STORMWATER MANAGEMENT PLAN (SWMP)

Public High School: **Palmer Ridge High School, 19255 Frontage Road, Monument, CO 80132**

"This *Grading, Erosion and Sediment Control (GESC)* document has been placed in the project file for this project and appears to fulfill the latest version of the *Grading, Erosion and Sediment Control Manual*. Additional grading, erosion and sediment Control Measures may be required of the owner or his/her agents, due to unforeseen erosion problems or if the submitted plan does not function as intended. The requirements of this GESC document shall run with the land and be the obligation of the landowner, or his/her designated representative(s) until such time as the plan is properly completed, modified or voided."

Phase 1
GHX / Ctrl Plant
INITIAL EROSION CONTROL PLAN

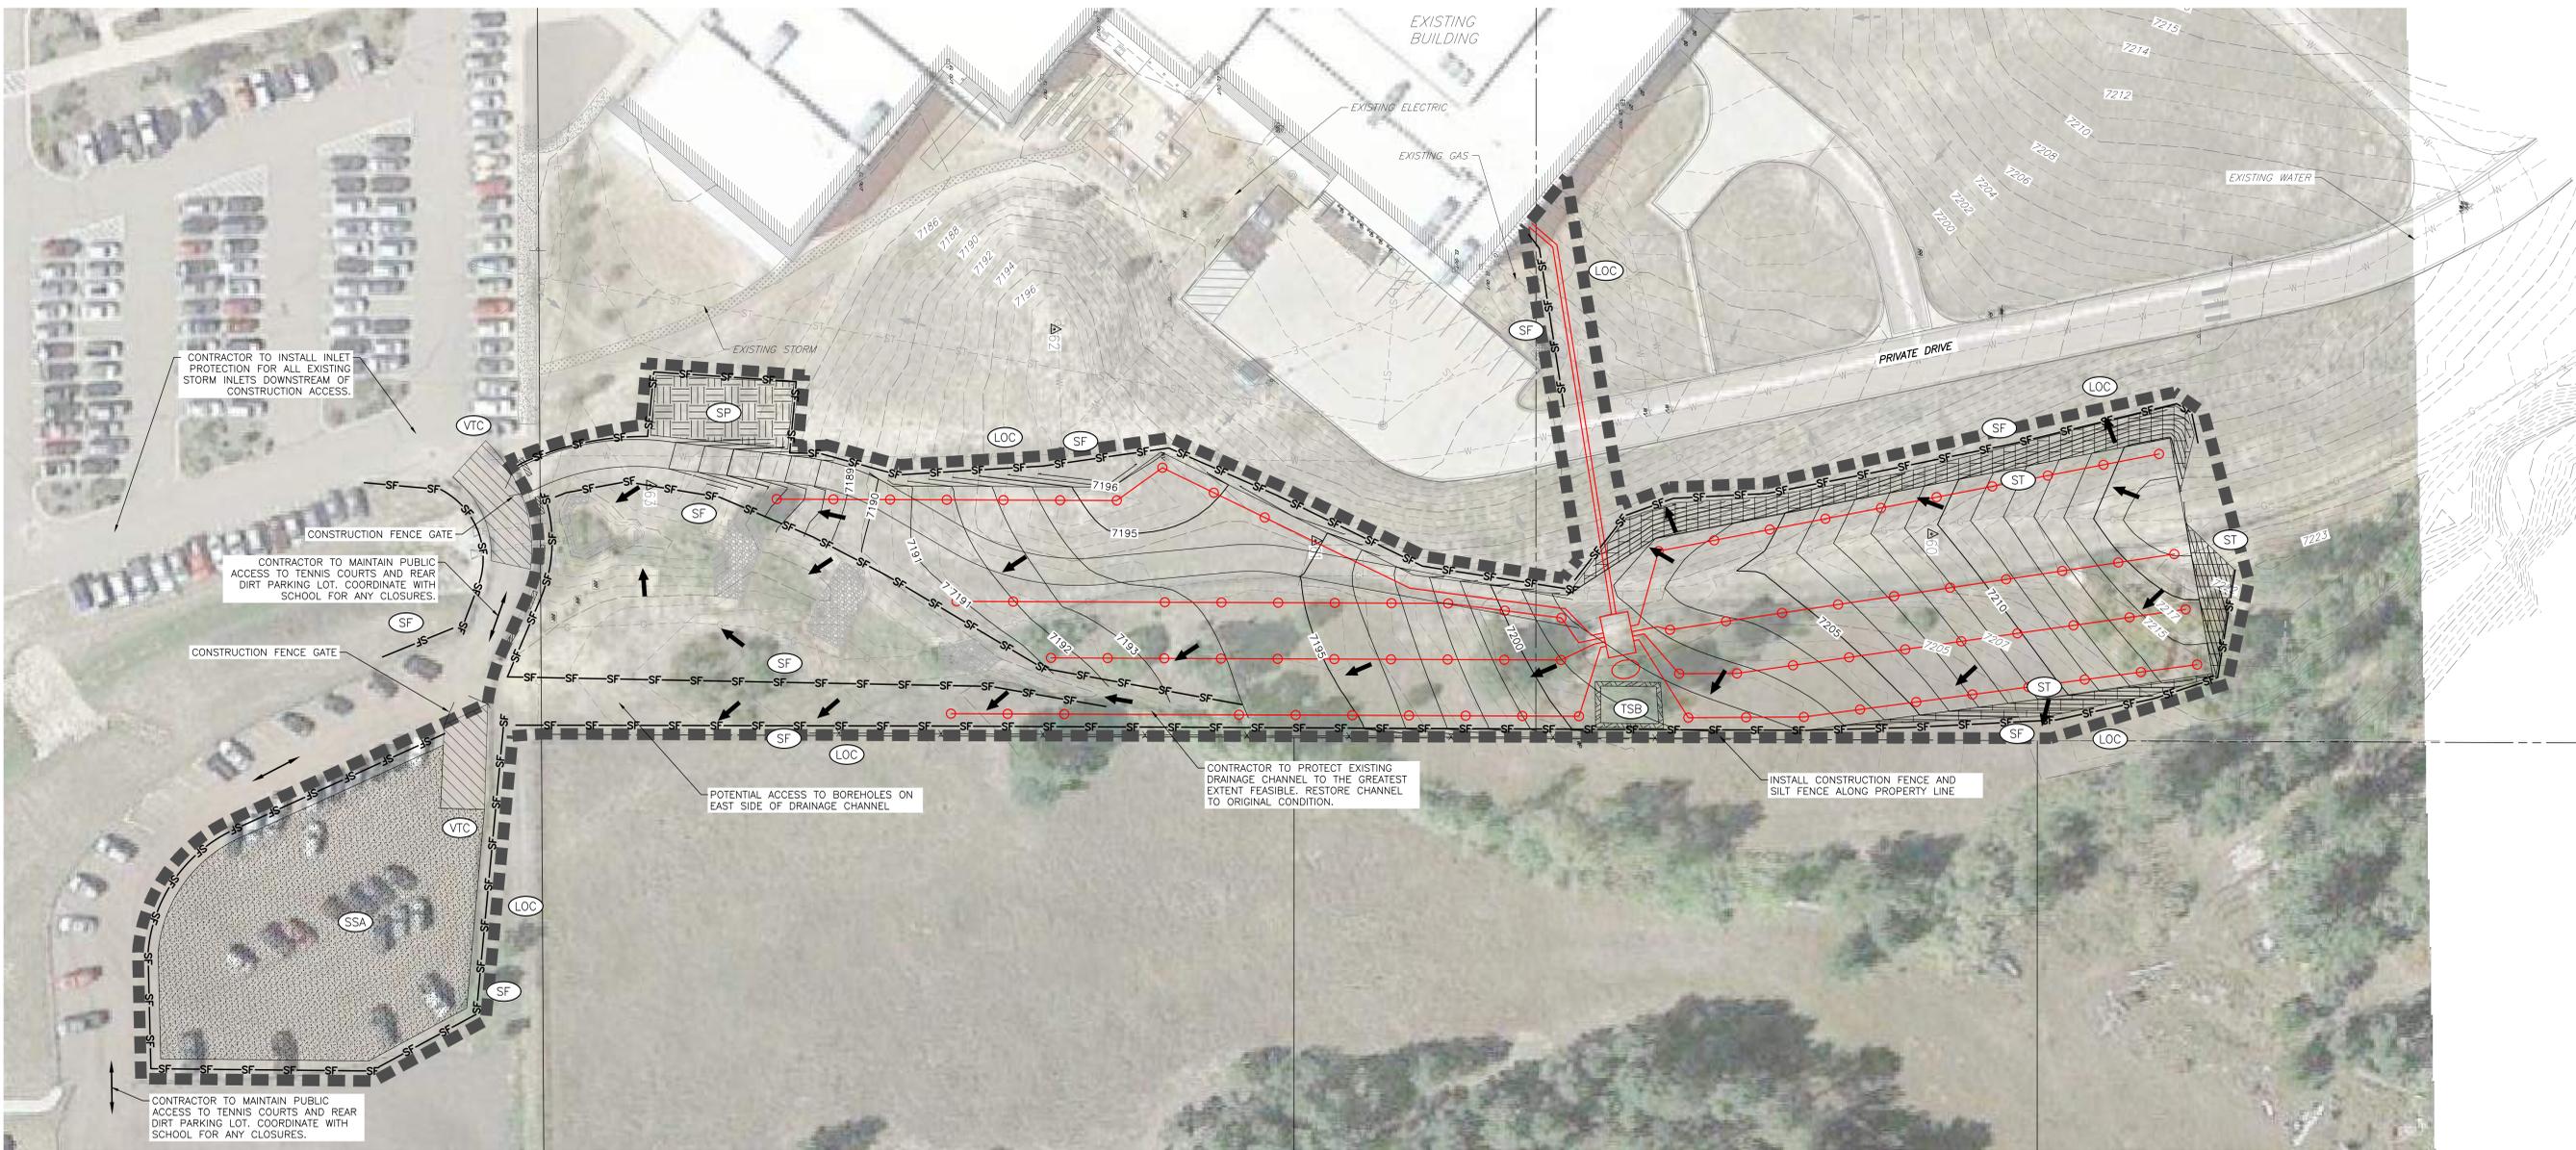
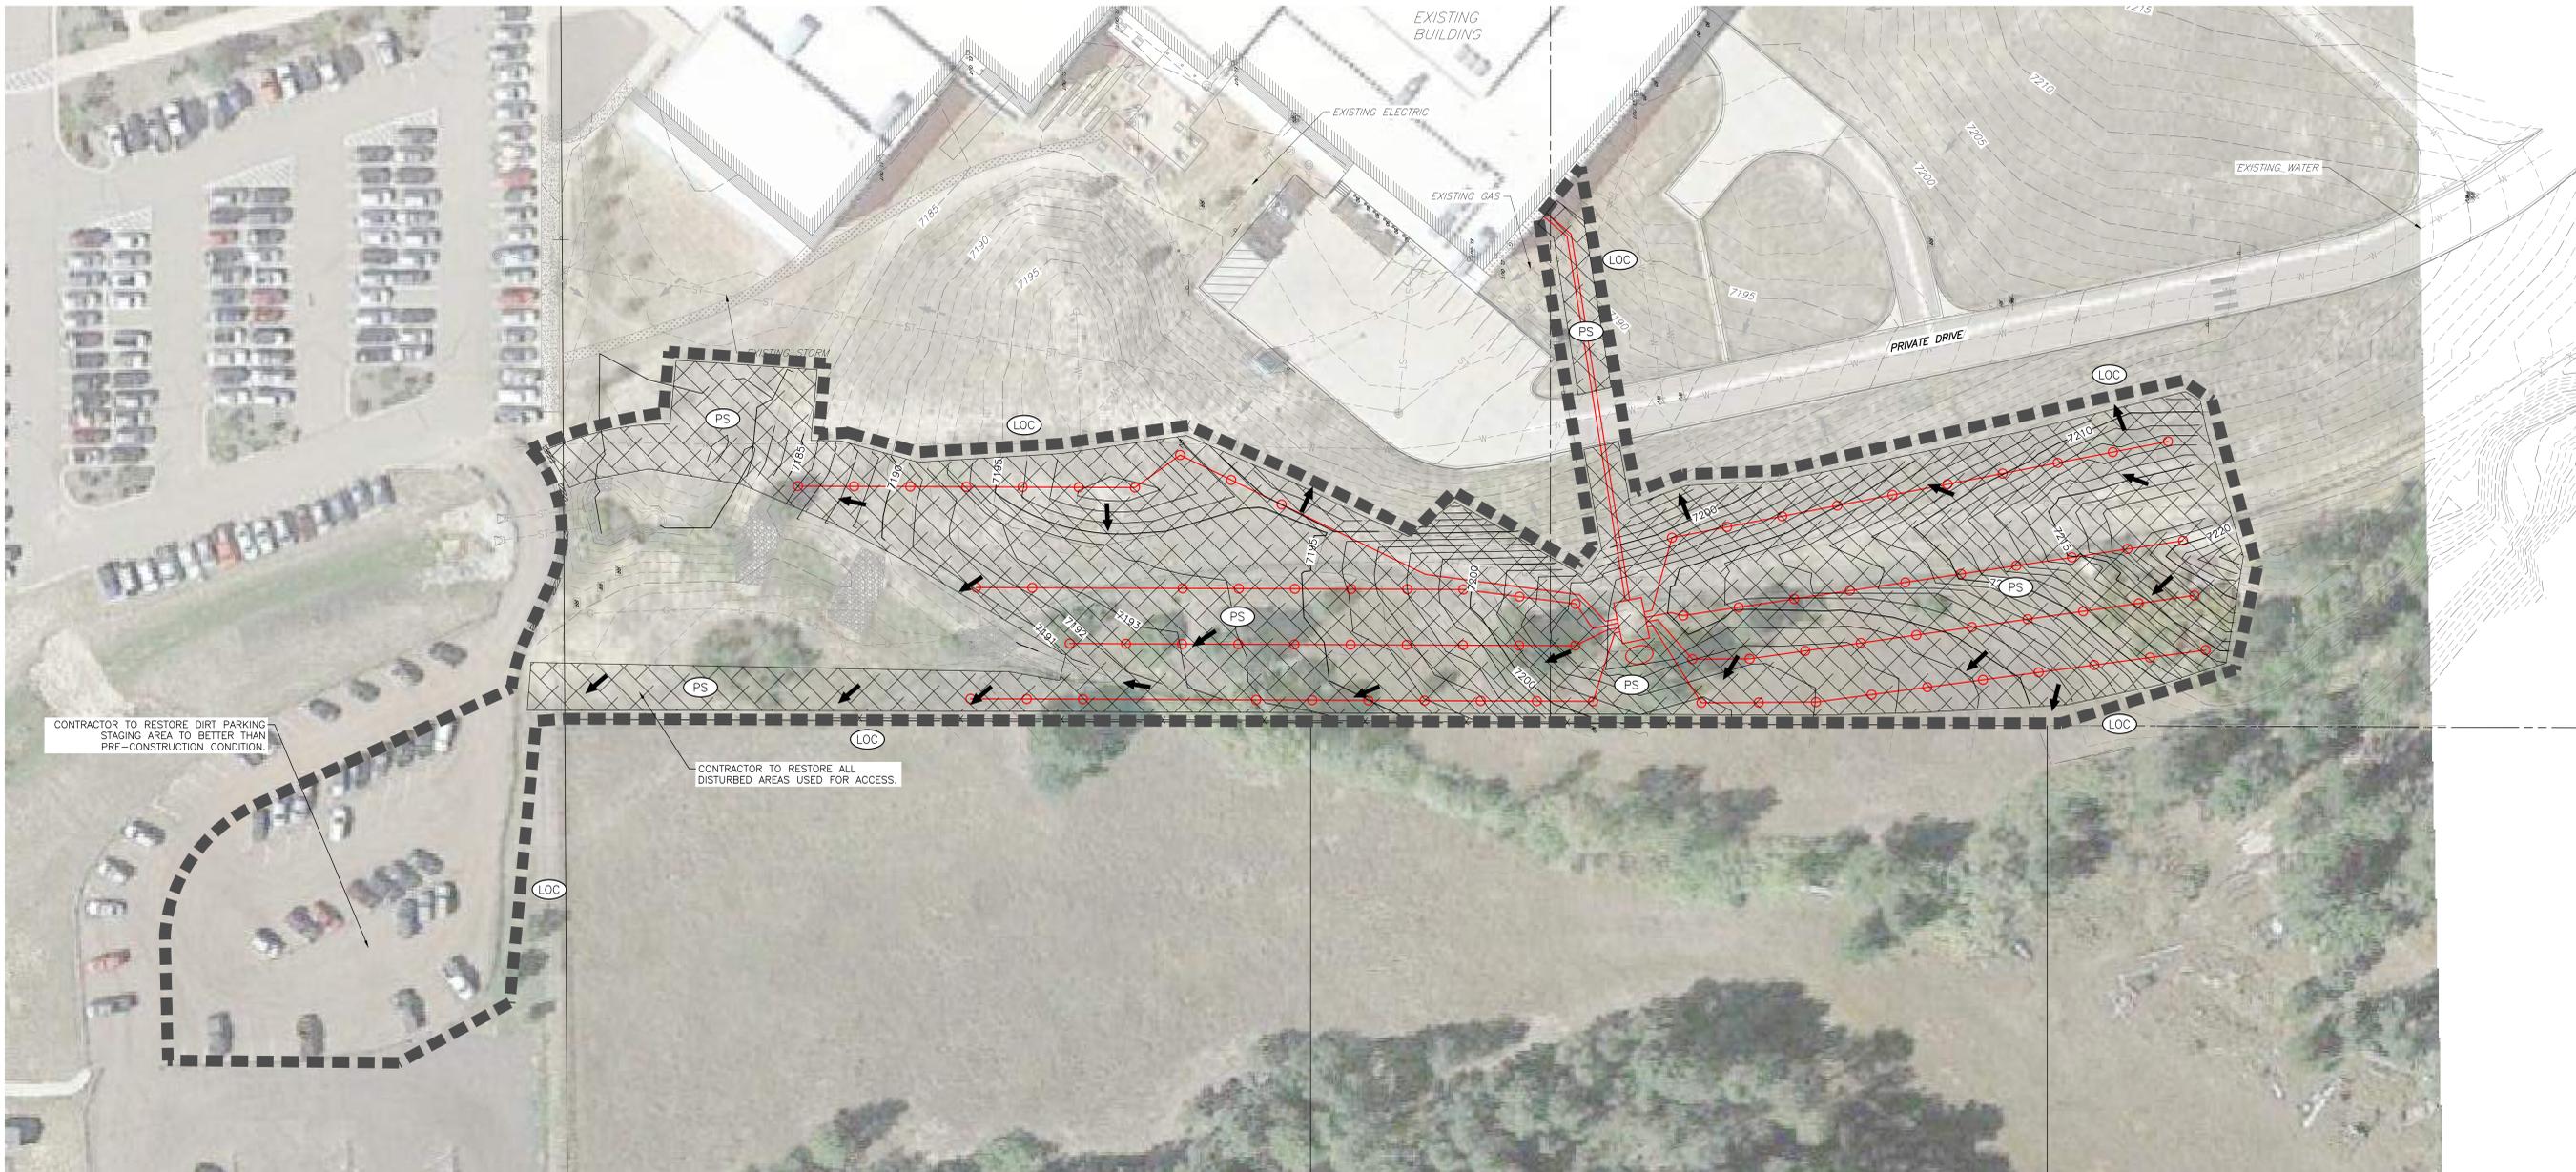
Item 1. Add Qualified Stormwater Manager and Contractor Information to cover/title sheet. If unknown, add a placeholder to be updated prior to the pre-construction meeting:
